RE: Spring Tree Ranch Rezone (RZ-24-00002 / CP-24-00002)
Applicant: Pat Deneen
Applicant: Spring Tree Ranch LLC (Owner)

The following signed property owners surrounding this proposed redevelopment of Spring Tree Ranch LLC are submitting this request for Kittitas County Development Services to **DENY** the application as written and proposed due to numerous issues that have not been addressed in the preliminary application. If more information is provided for issues below, we still believe approval will harm the peace, repose and use of our respective properties surrounding the redevelopment area and negatively affect our properties and their respective values.

REVISED SPRINGTREE RANCH MASTER PLAN - SITE PLAN

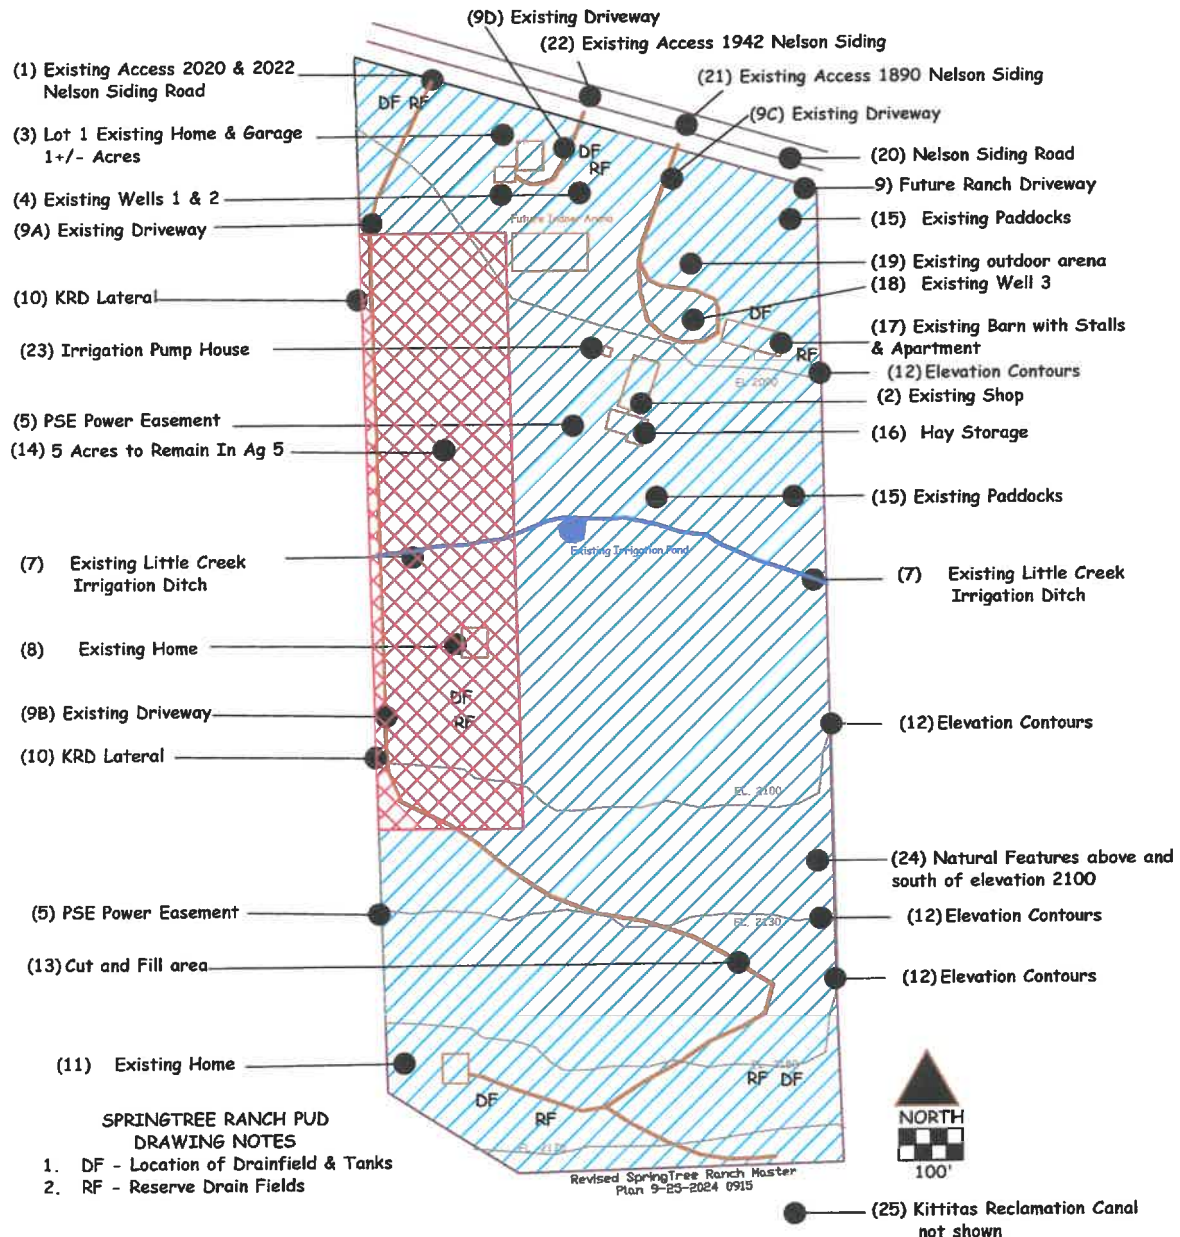
- The proposed indoor arena, according to the map, is directly adjacent to the property lines of parcel 13632 (2144 Nelson Siding Rd) and parcel 13630. What is the proposed set-back from any indoor riding arena from the parcel line? What is the expected noise (DB) increase from this proposed riding arena that will affect these lots and what methods of mitigation are proposed?

- The map and proposal intends to make one large lot of 27.27 acres. Should we be expecting another proposal to subdivide in the future to sell off these homes?
